Our reference: P-342395-K2K1
Contact: Robert Craig
Telephone: (02) 4732 7593

3 August 2022

Section 4.55(2) Modification Application: SSD-11070211-Mod-1 – Proposed Primary School at 60-78 Deerubbin Drive, Glenmore Park

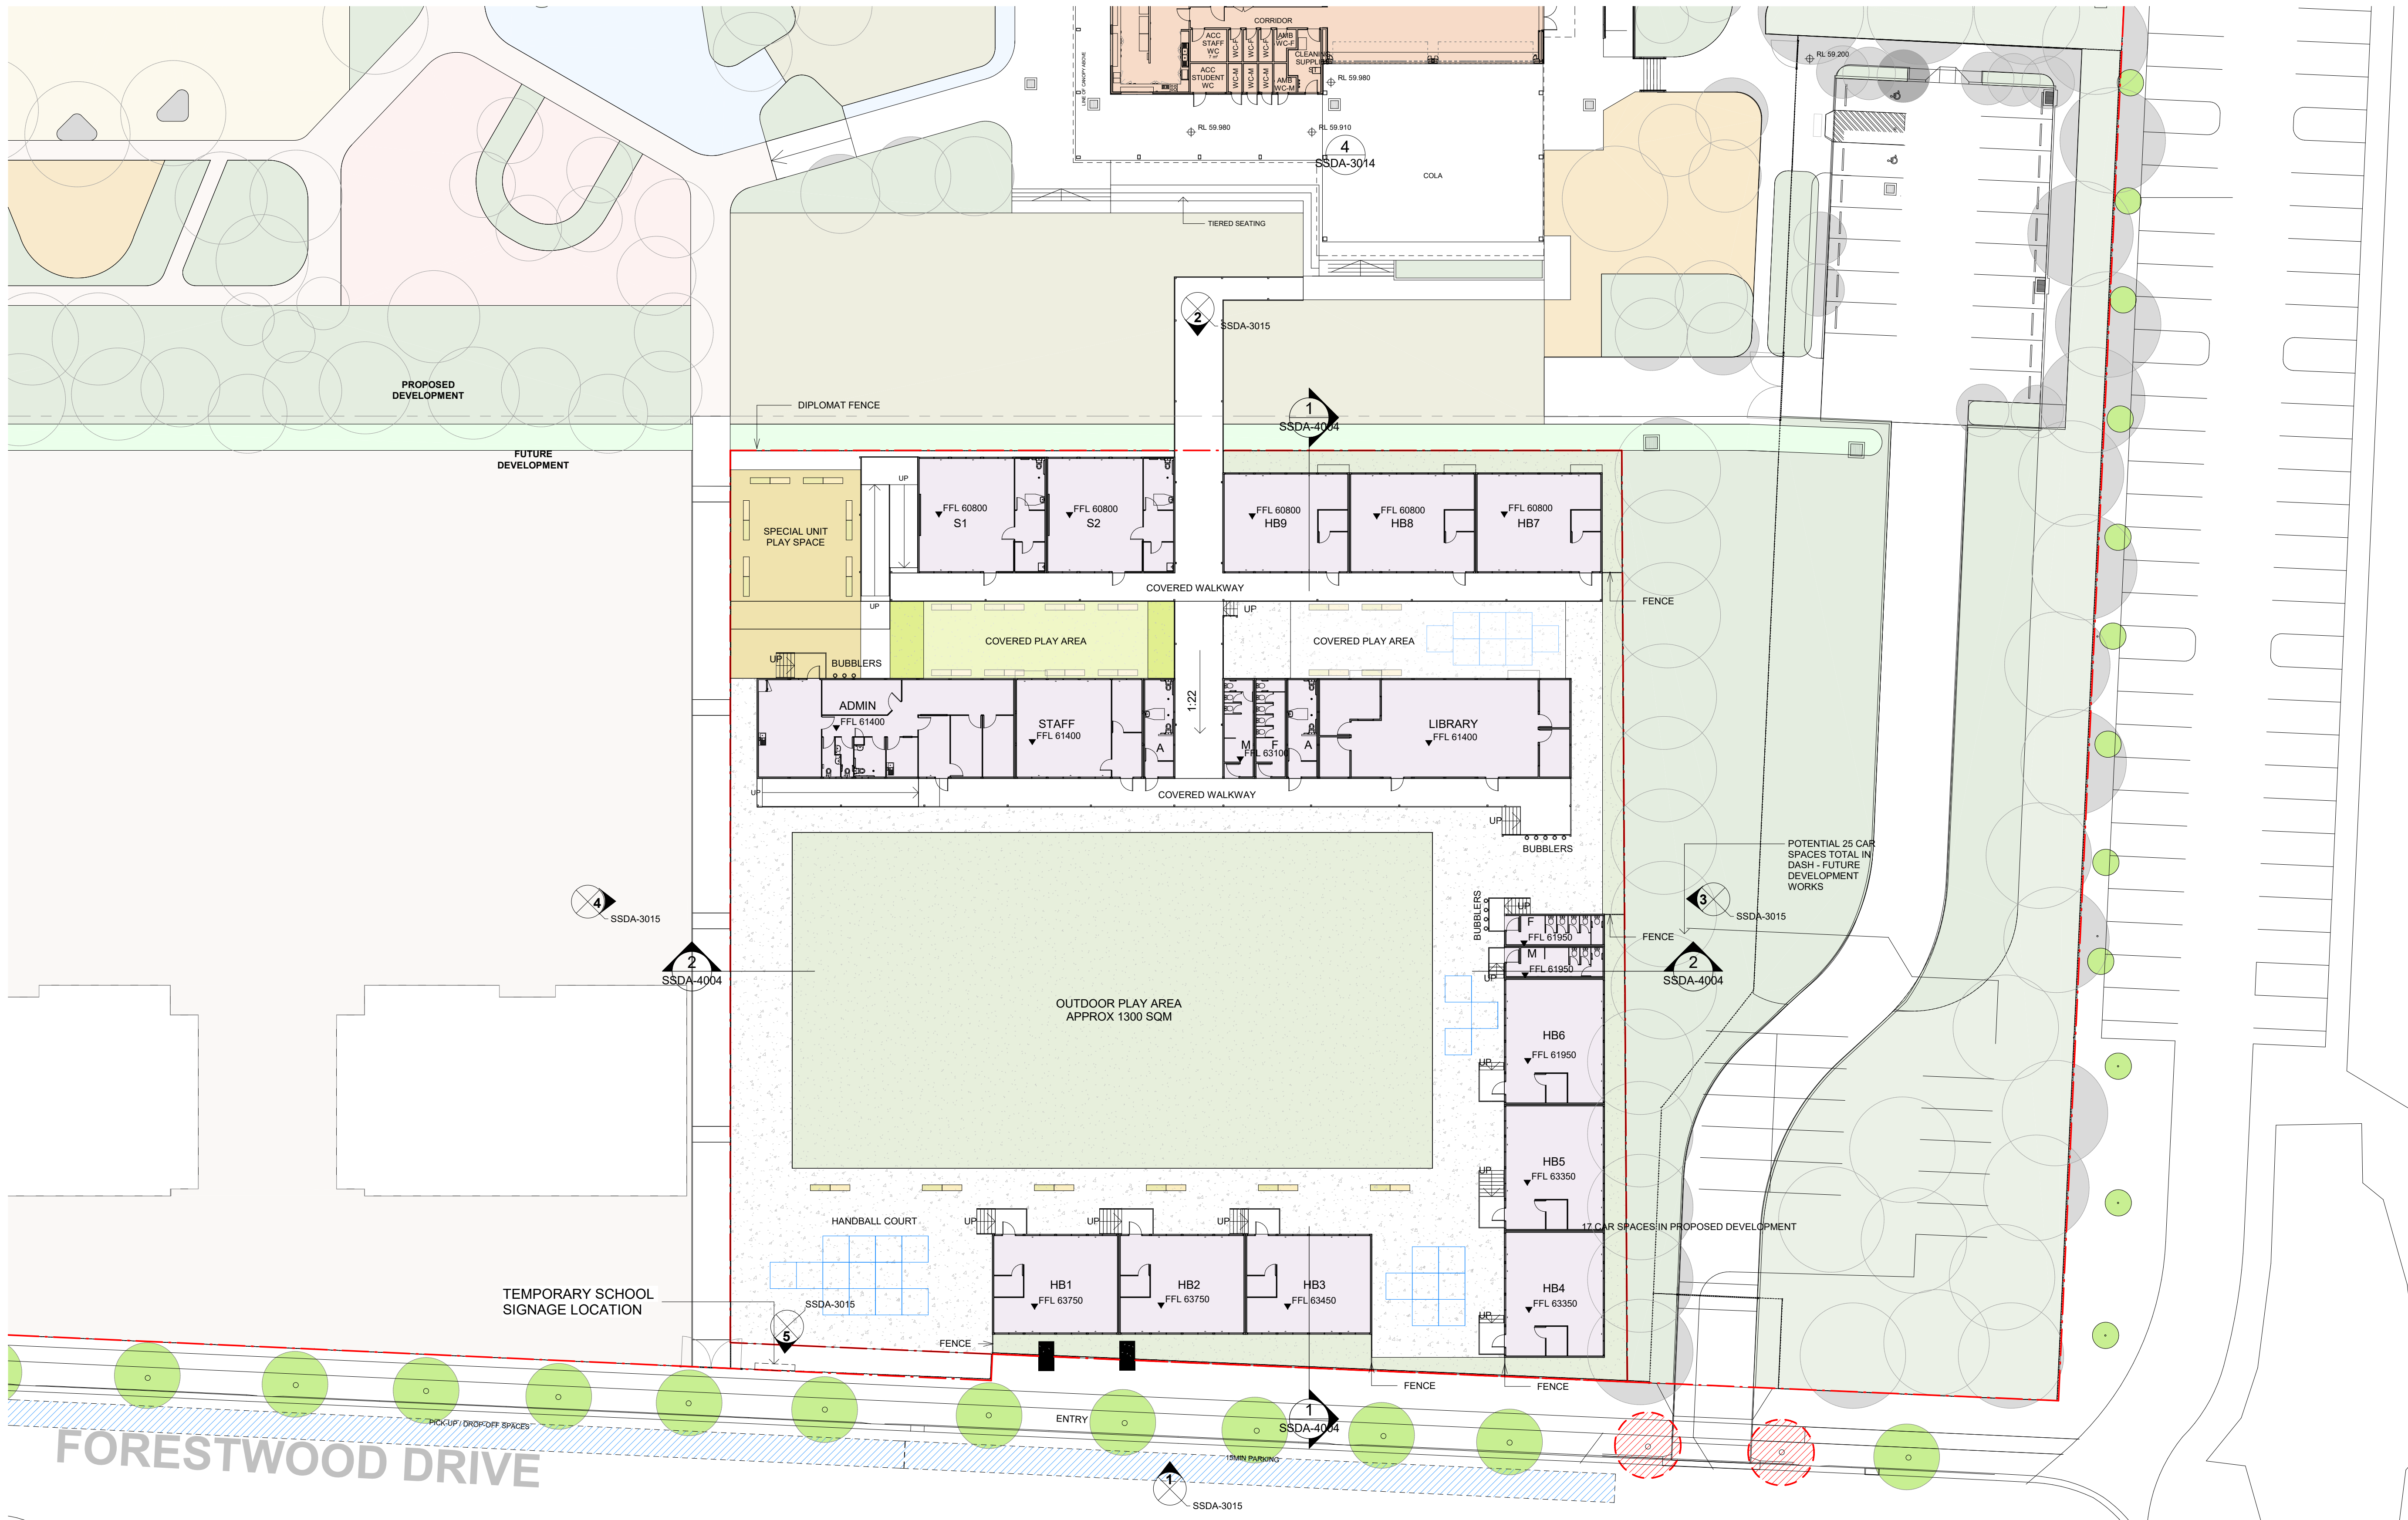
The proposed setbacks of the demountable buildings from Forestwood Drive have not been nominated on the plans. The plans should be updated in this regard and consideration should be given to providing for street setbacks which, as far as possible based on available space, are characteristic of the dwelling setbacks on the southern side of Forestwood Drive.
